# **CHATBURN PARISH COUNCIL**

18 April 2019

**Planning Application No. 3/2019/0091 – Greendale View**

SHEET:
SITE PLAN

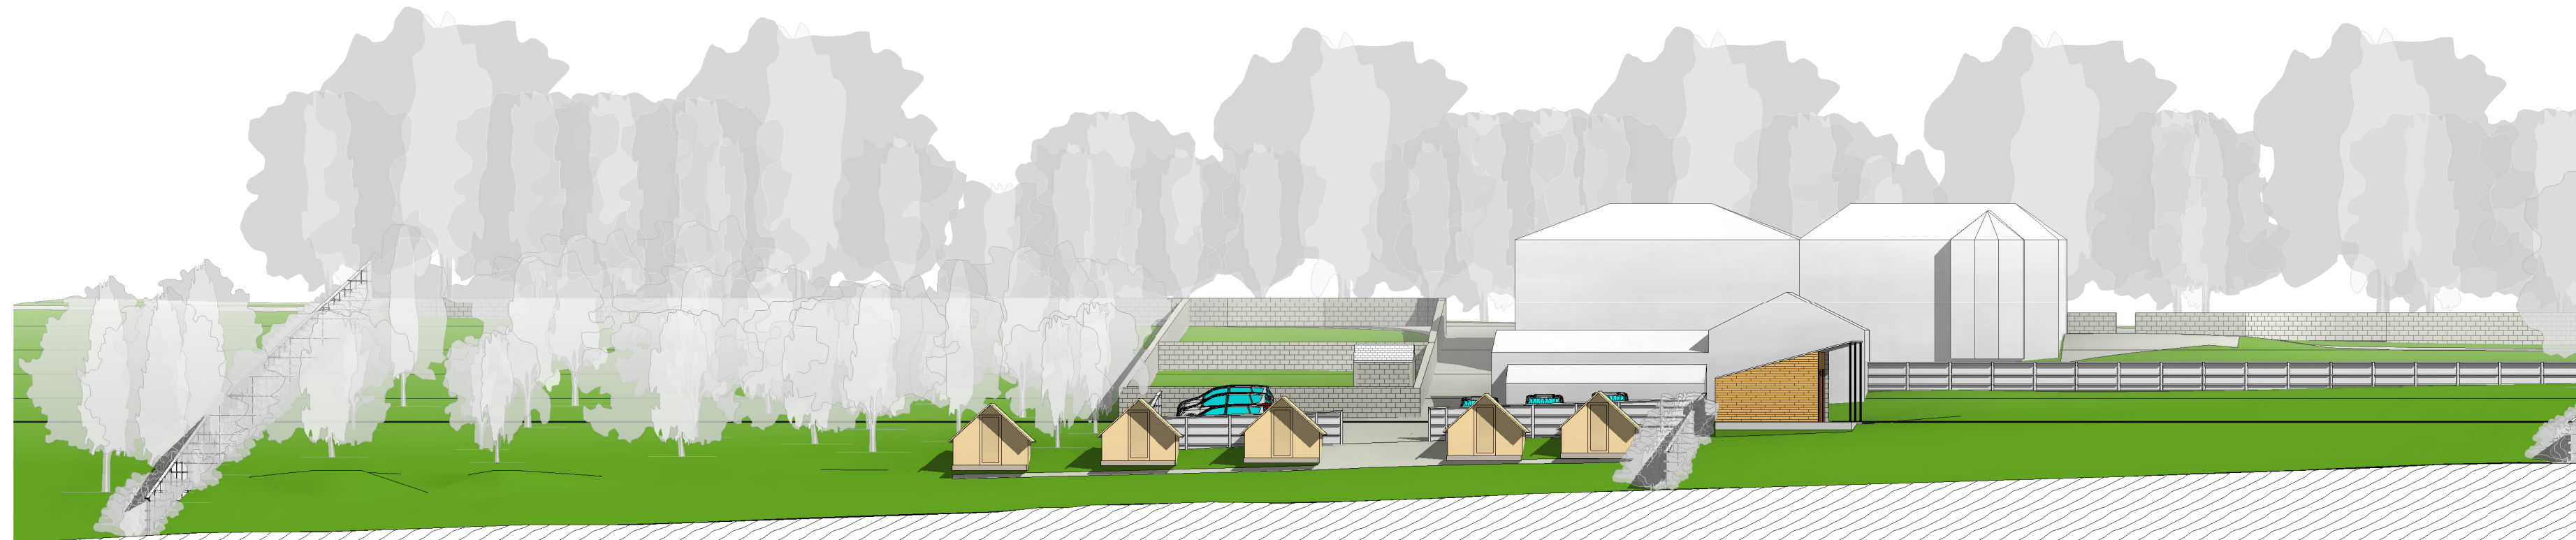
Chatburn Parish Council has viewed the above planning application and is concerned about the access to and from the property on to a narrow and extremely busy road. The visibility is poor and there is no footpath.
